EAST ANGLIA ONE NORTH

EAST ANGLIA TWO

Questions for the applicant in response to

SEAS (Suffolk Energy Action Solutions)

| Important Hedgerows and Tree Preservation Order Plan Sheet Number: Sheet 2 of 12 | | | Rev | 5 | British National Grid OSGB36 |

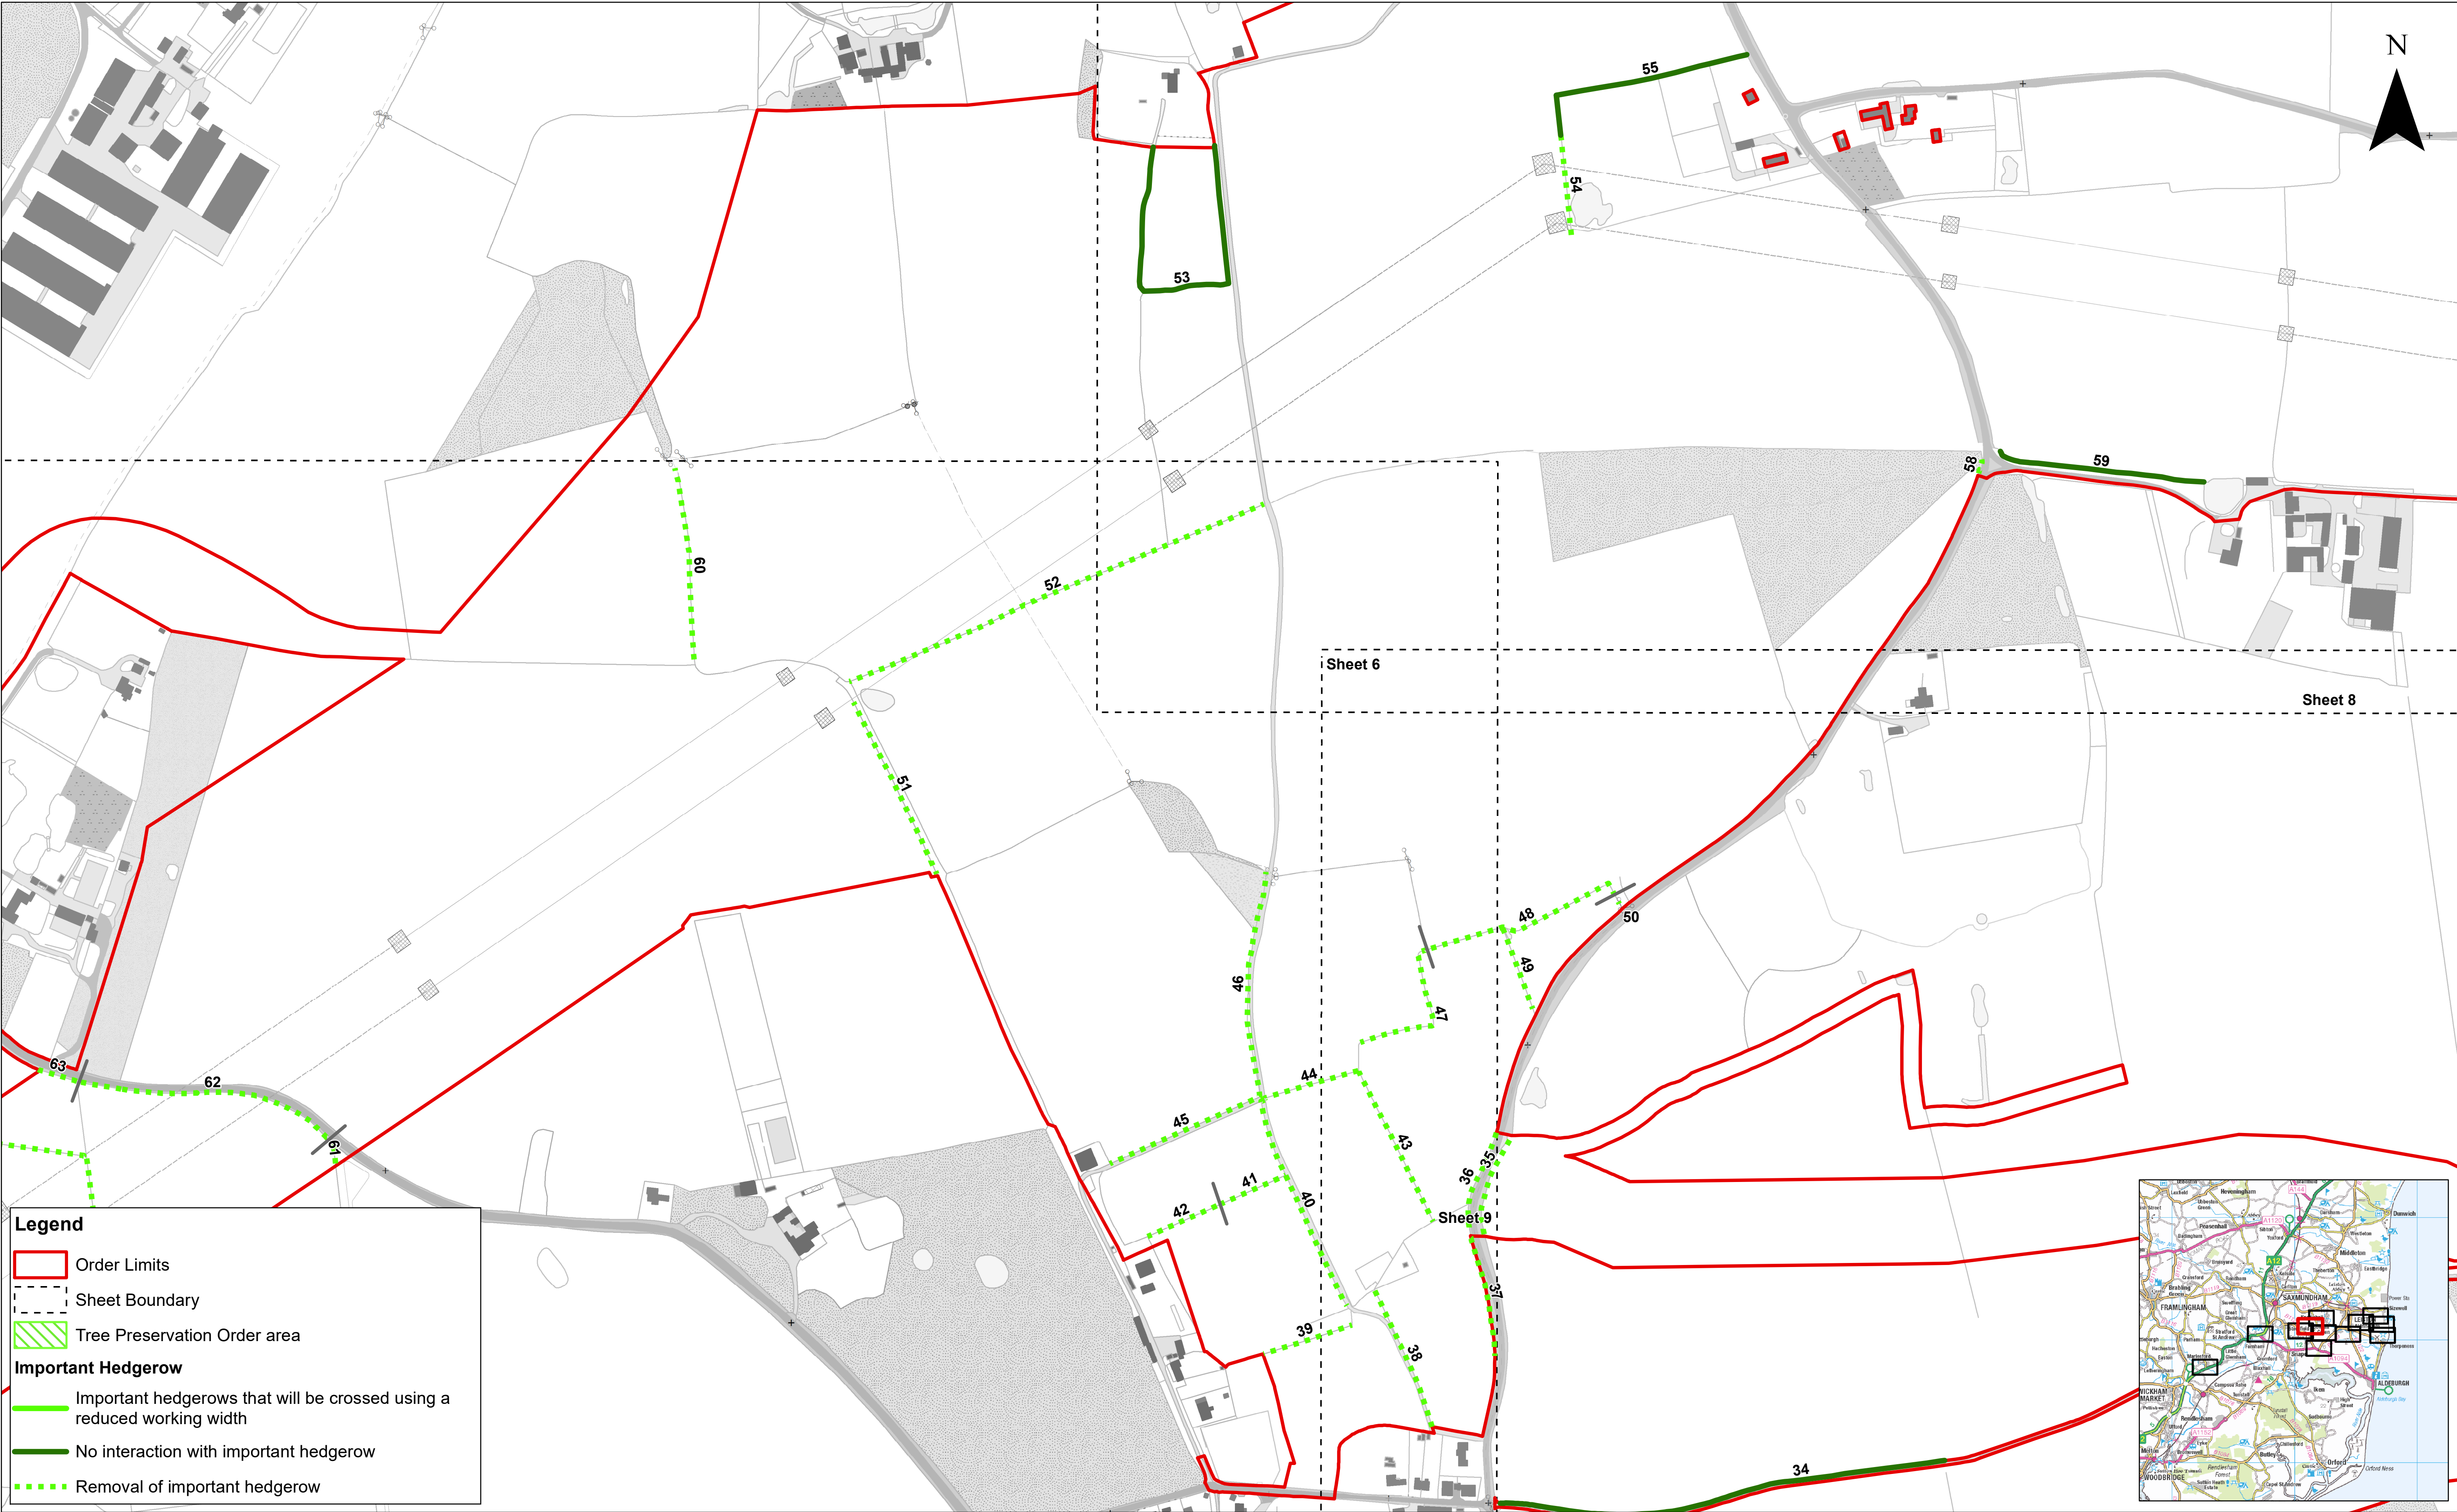
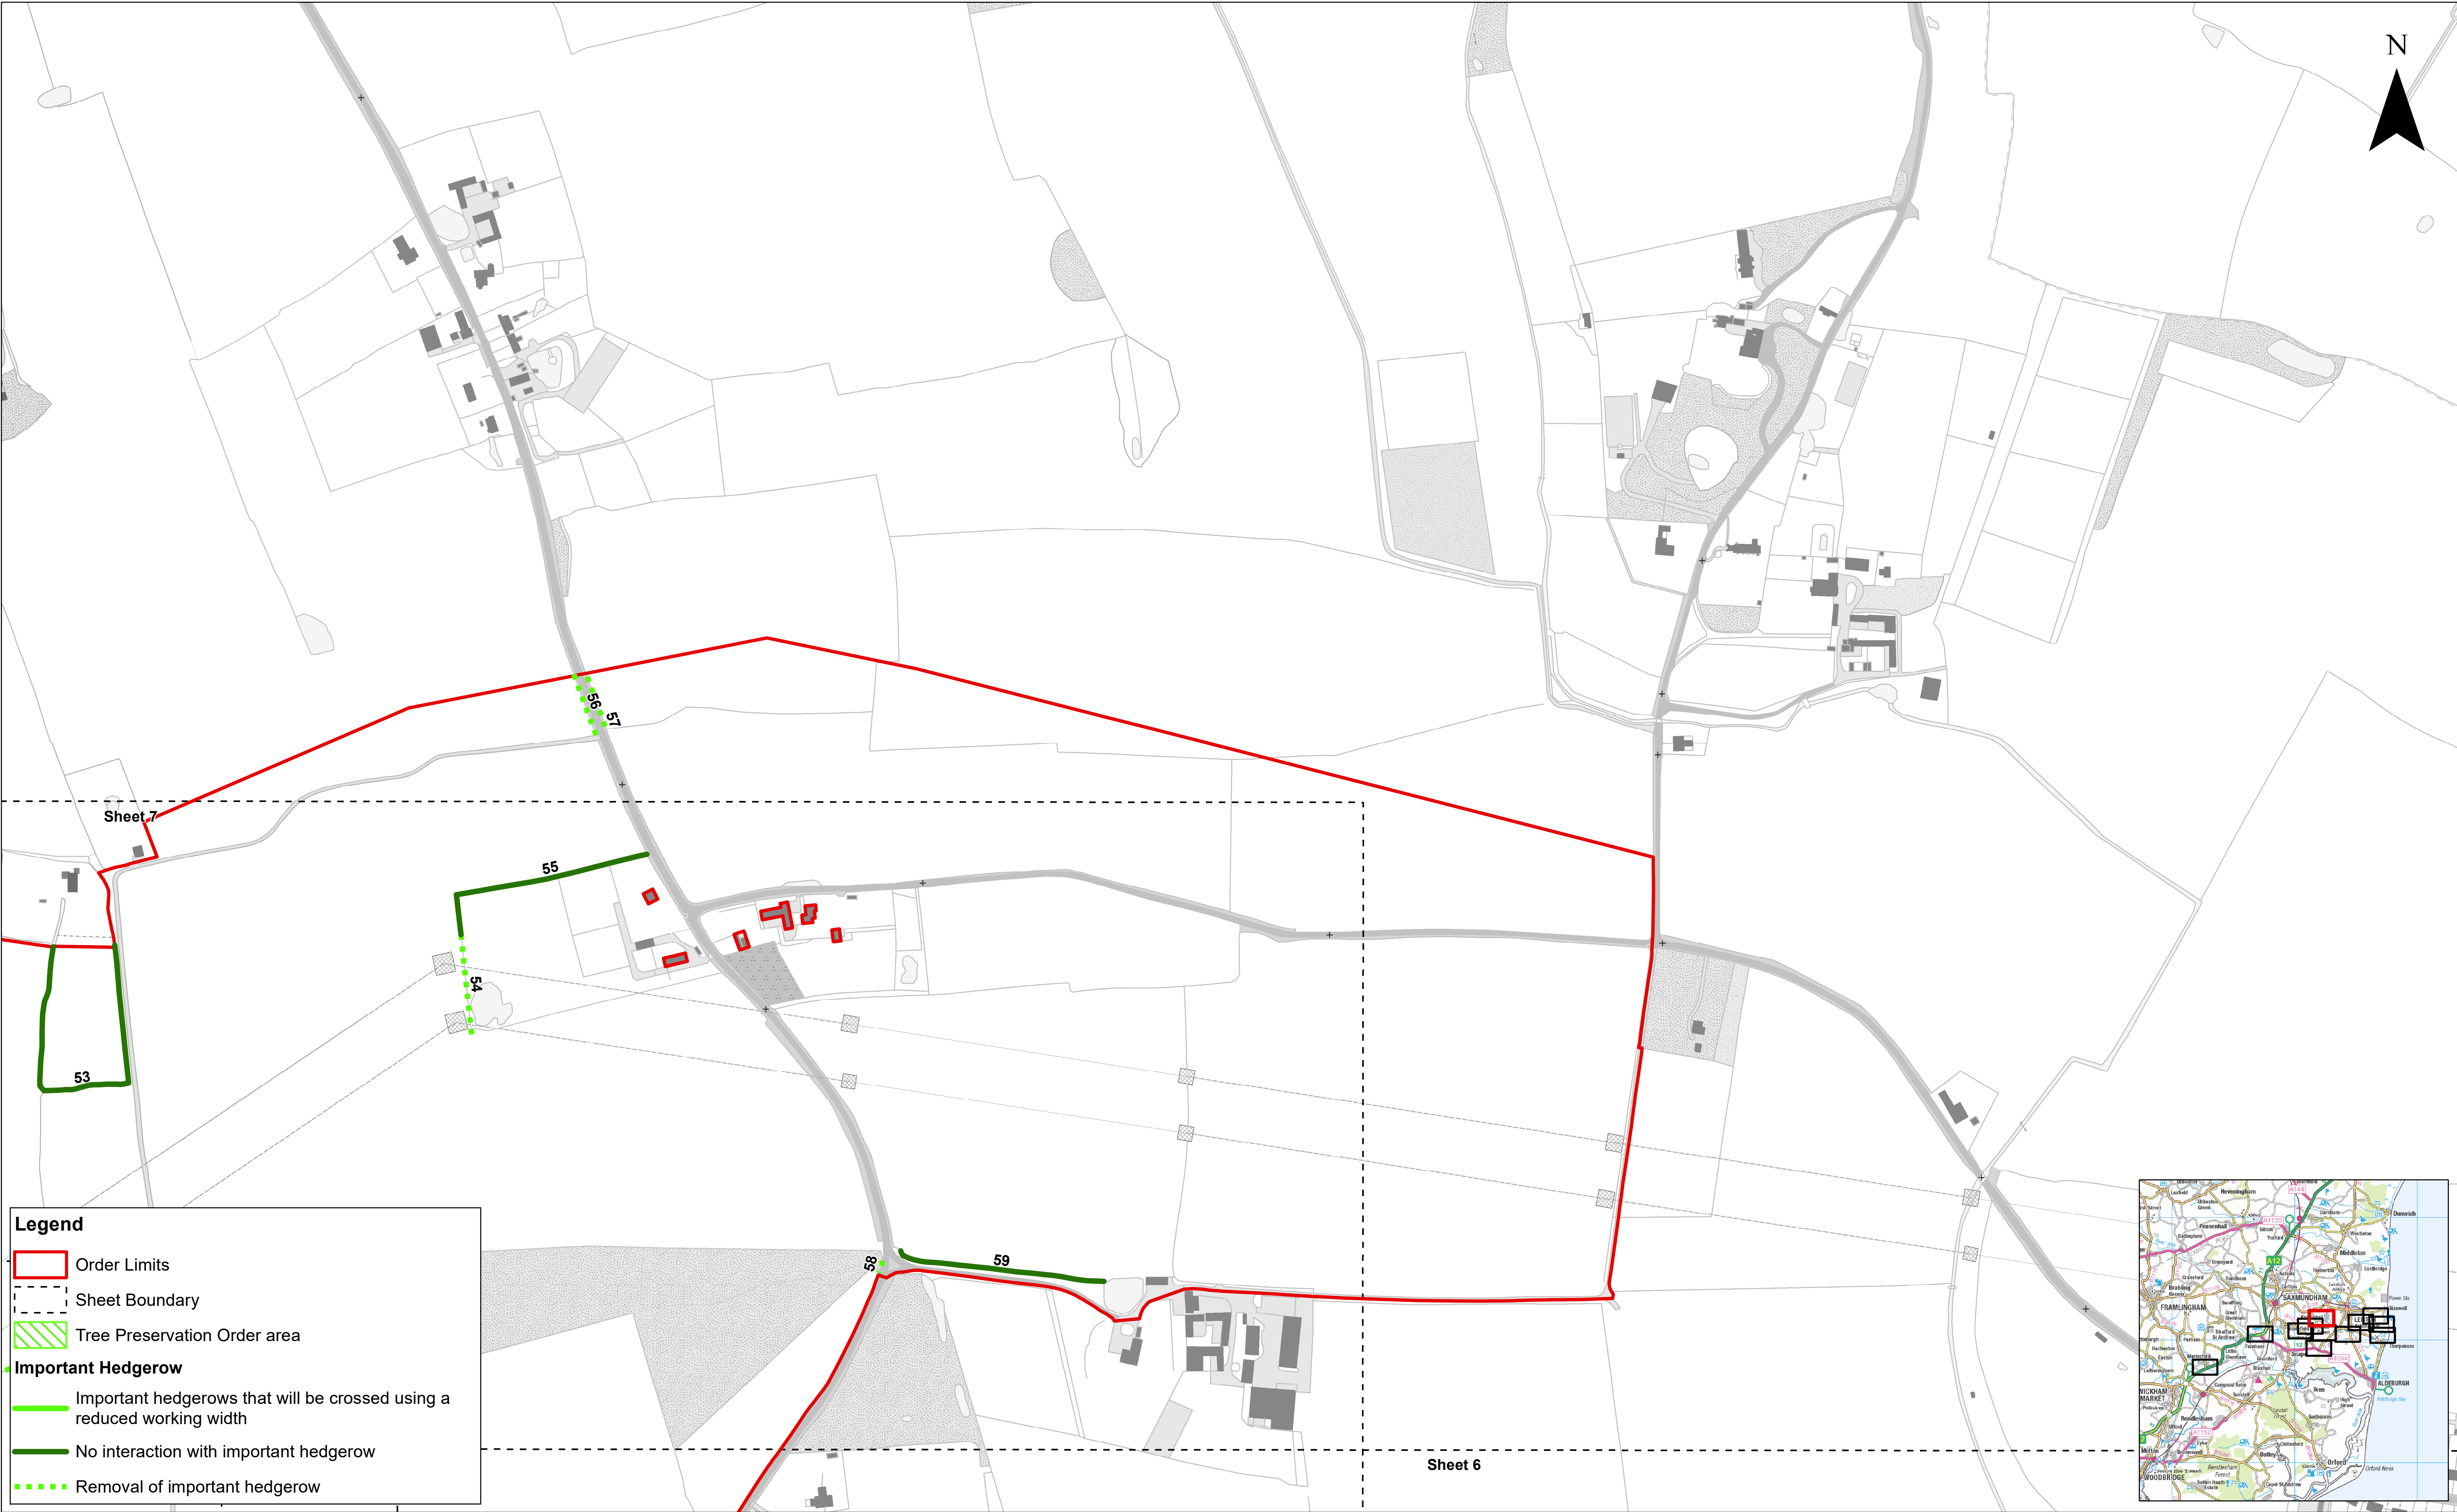
2.3.2 Moving westwards from the sea, SPR proposes to remove around 11km of hedgerow, most of which appears on maps published in the 1800s. In Aldringham, SPR will grub up section CS19-CS20 of Hedgerow 20 beside PROW path E-106/065/0, and Hedgerow 21 alongside E-260/007/0 Fitches Wood, Aldringham.
